APPLICATION NO: BN/66/19/PL

Site Address: Land off Canal Mews Barnham PO22 0AB

Description of Works: Erection of 3 No dwellings.

Rev H 12/02/20 Plot 1 reduced in width.

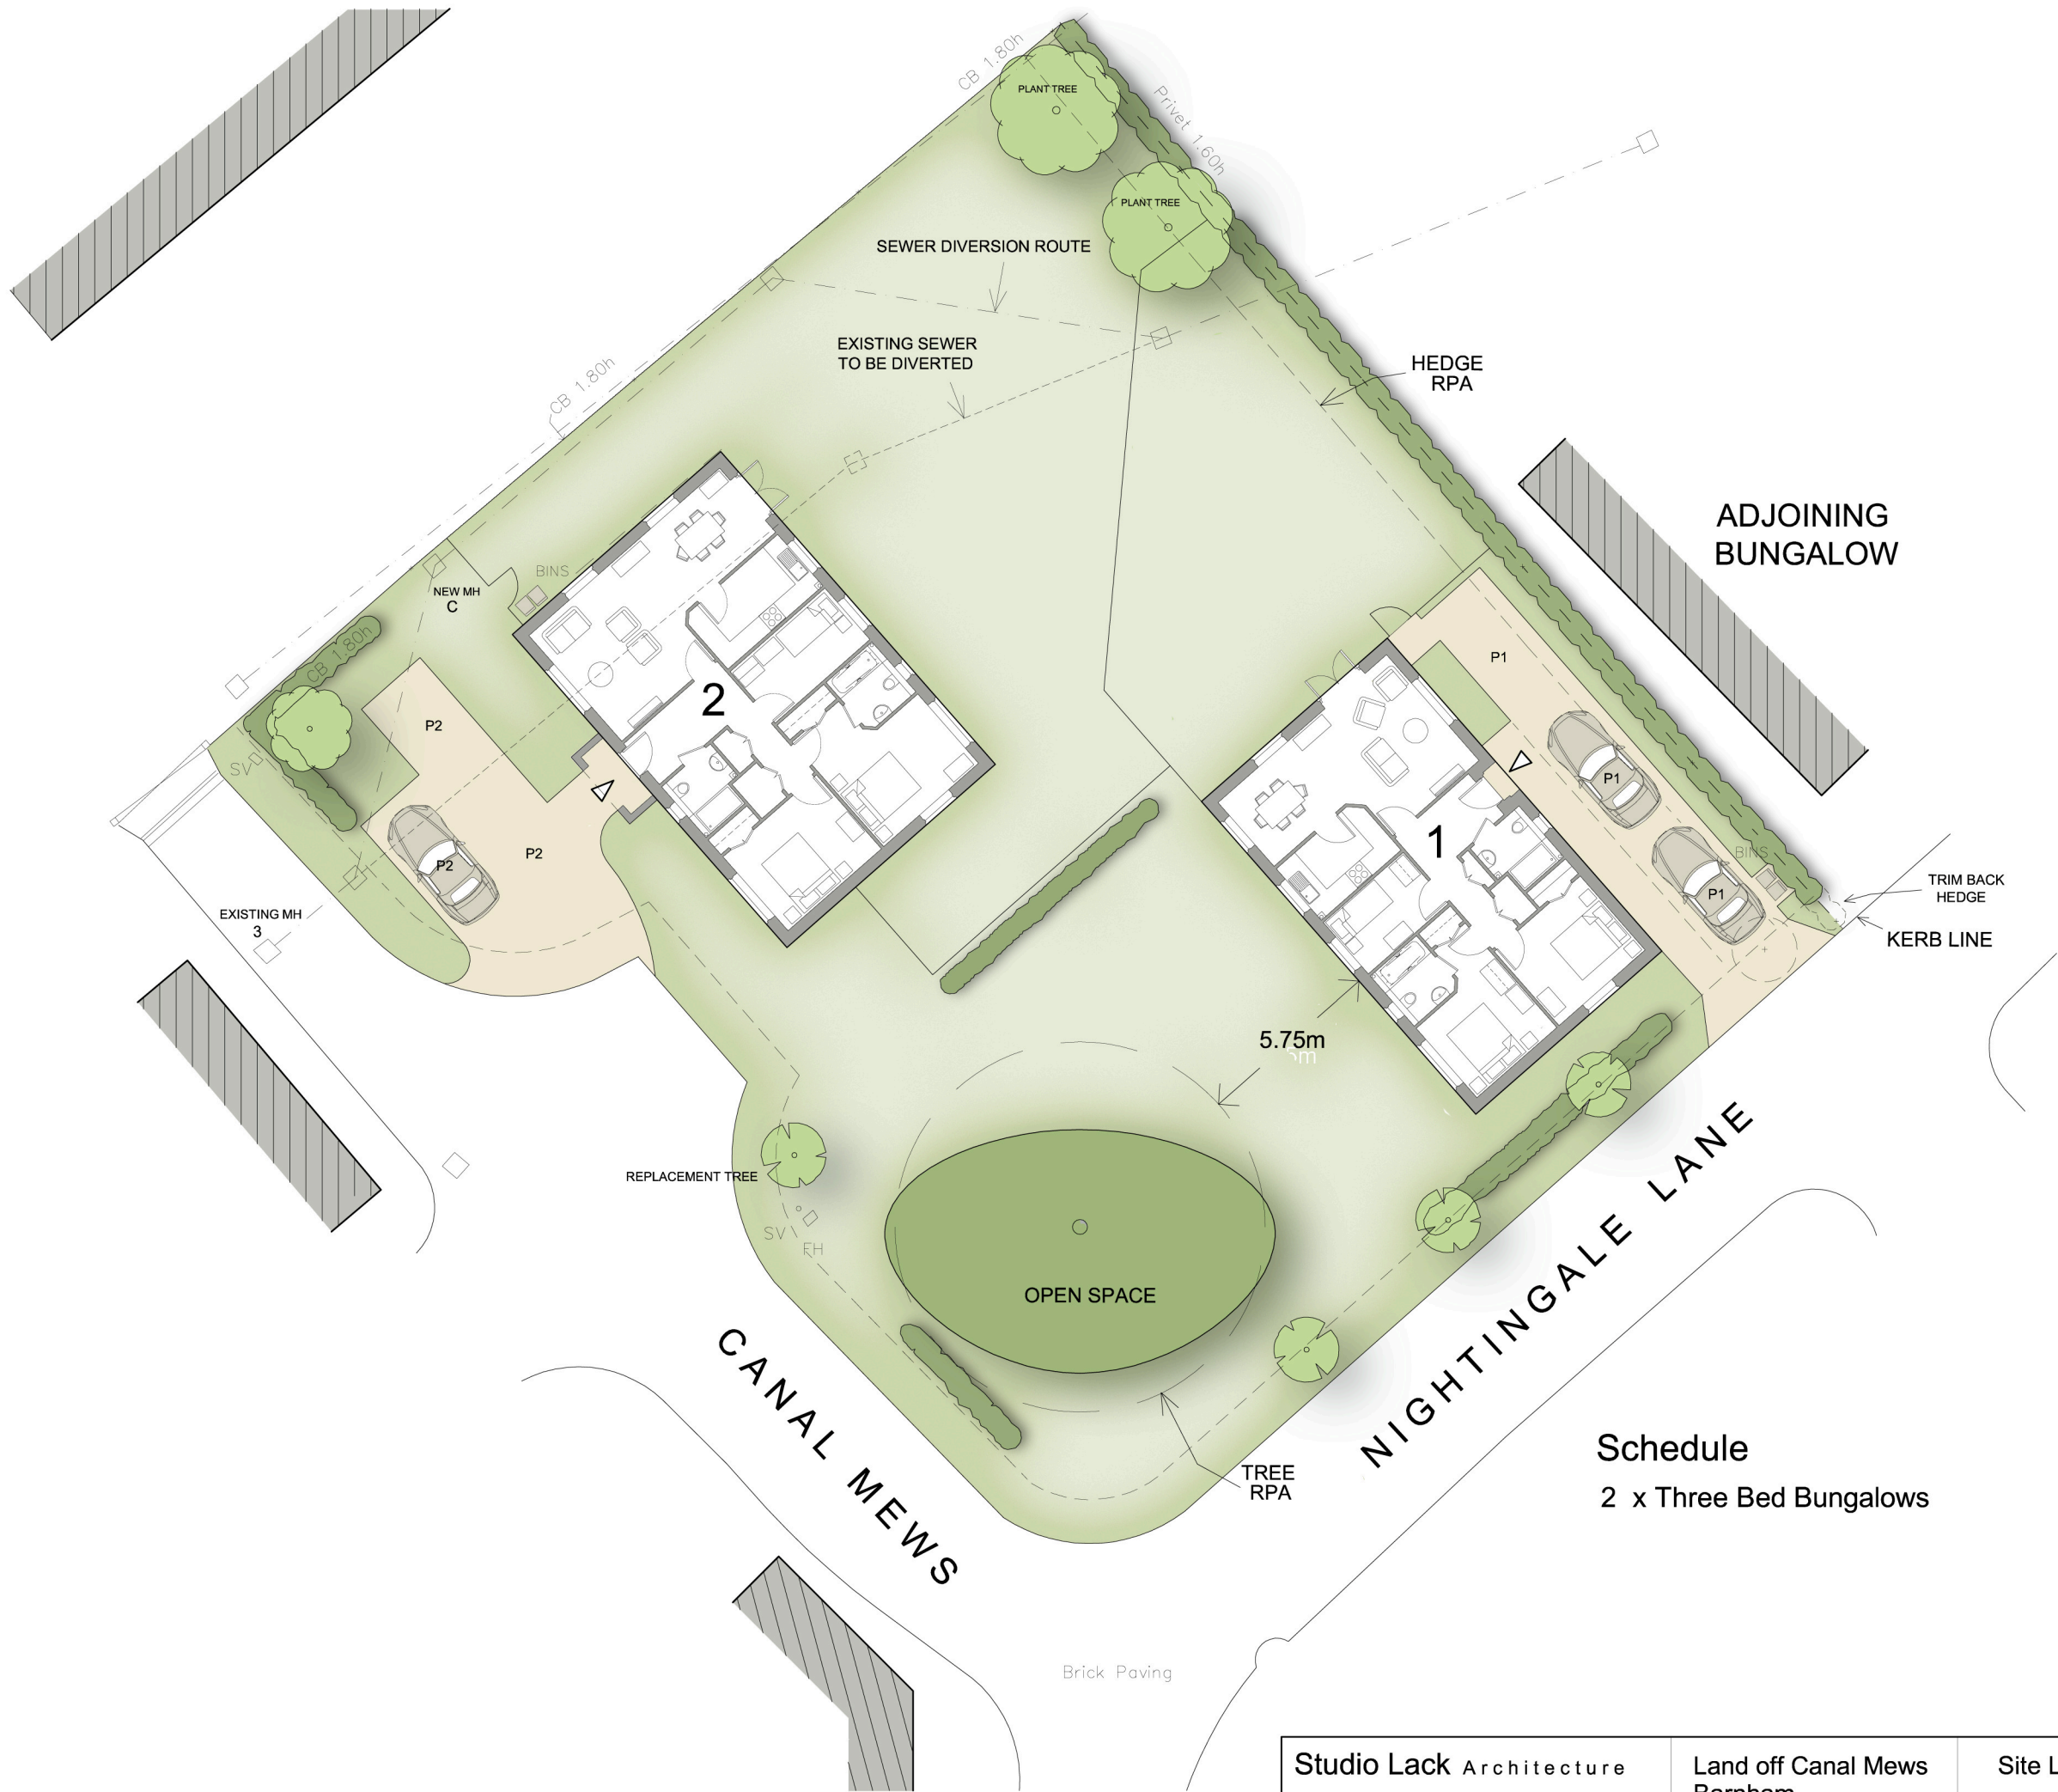
Based on the latest plan dated 22nd January the proposed dwelling is now outside the RPA and Mark would no longer object. I therefore suggest that you submit revised plans on this basis.

Further to your email confirmation below, I now attach the duly revised plans which we request are substituted for the submitted originals. The revised block plan shows the new siting of the 2 bungalows and the site layout plan showing the separation distance with the tree is now coloured. The floor plans and elevations of the 2 plots are also revised. The drawing issue sheet attached lists the plans withdrawn and the new substitute plans.
